WEST SUSSEX COUNTY COUNCIL CONSULTATION

TO:	Arun District Council FAO: Amy Myer
FROM:	WSCC - Highways Authority
DATE:	12 October 2021
LOCATION:	Crossbush Service Station Lyminster Road Lyminster BN17 7QQ
SUBJECT:	LY/15/21/PL Erection of a drive-thru coffee shop (Use Class E) with associated infrastructure. This application is in CIL Zone 3 (zero rated) as other development. This application is a Departure from the Development Plan.
DATE OF SITE VISIT:	n/a
RECOMMENDATION:	No Objection
S106 CONTRIBUTION TOTAL:	n/a

21220-MA-XX-XX-DR-C-7000 - P01

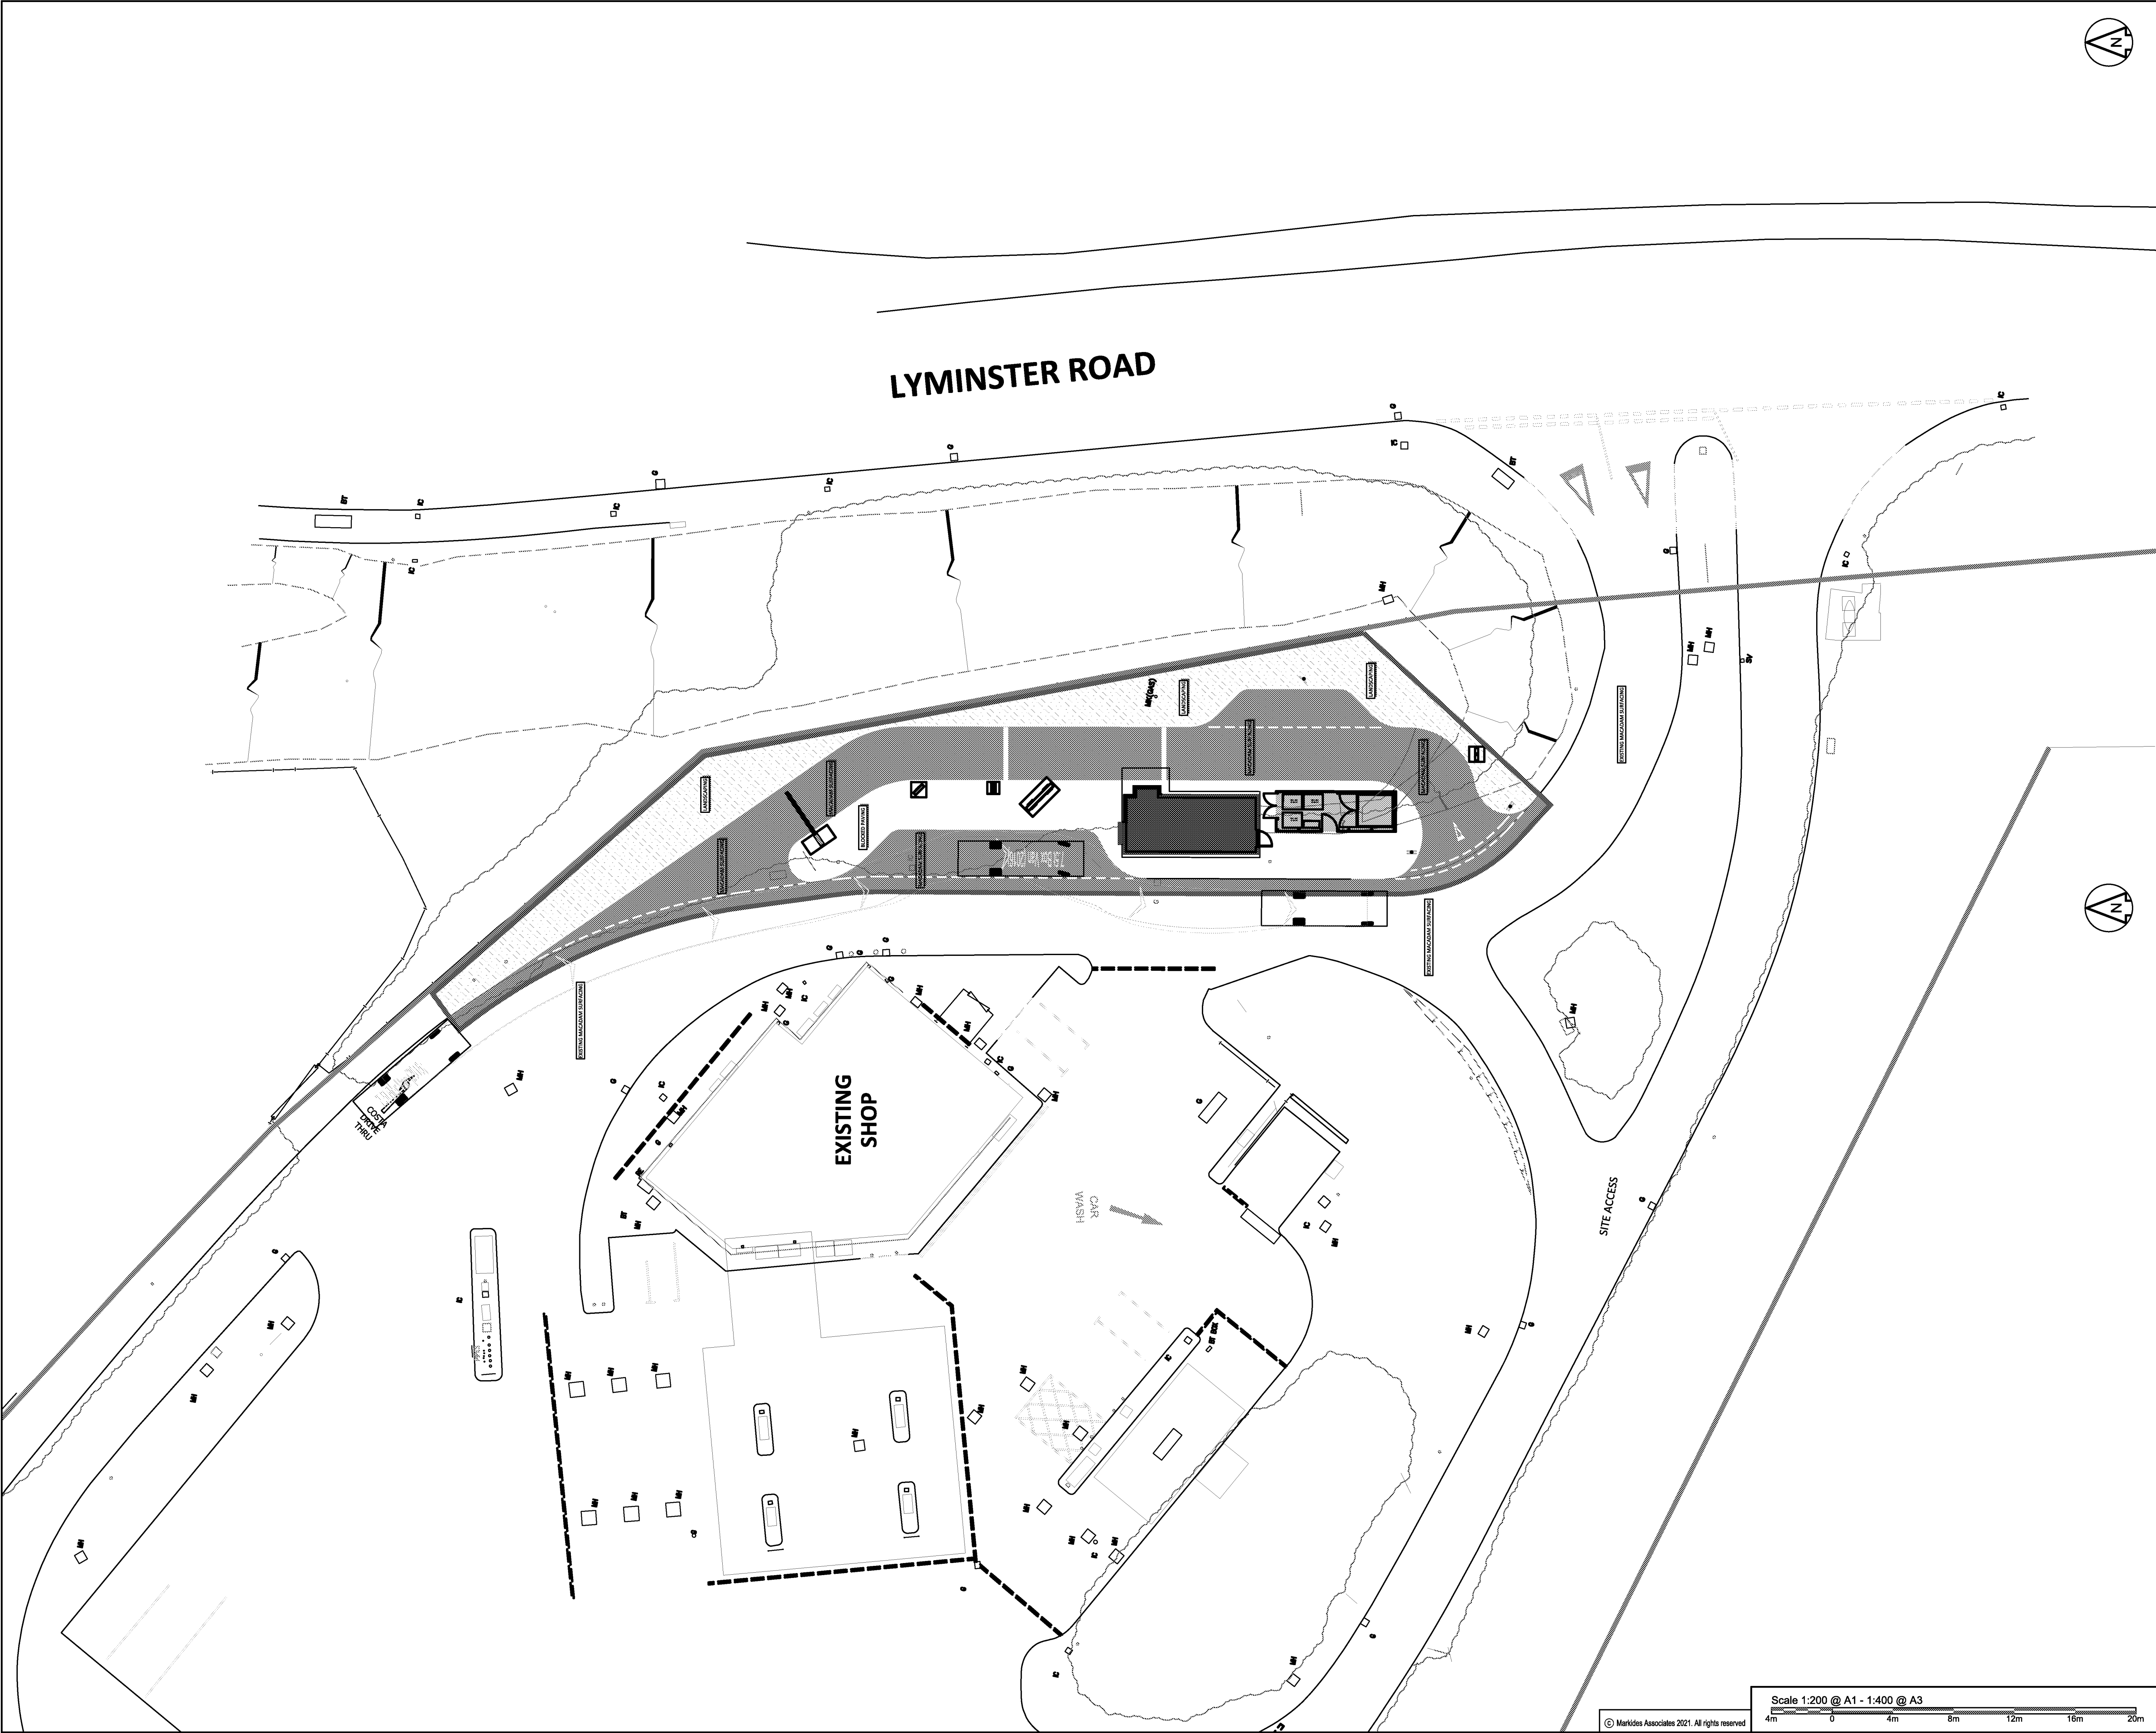
Swept path analysis carried out for the new drive-thru loop, waiting bay, and proposed delivery bay using a large car and a rigid truck demonstrates that the proposals are fit for purpose. Visibility splays are acceptable for vehicle speeds being low and generally not in excess of 10mph.
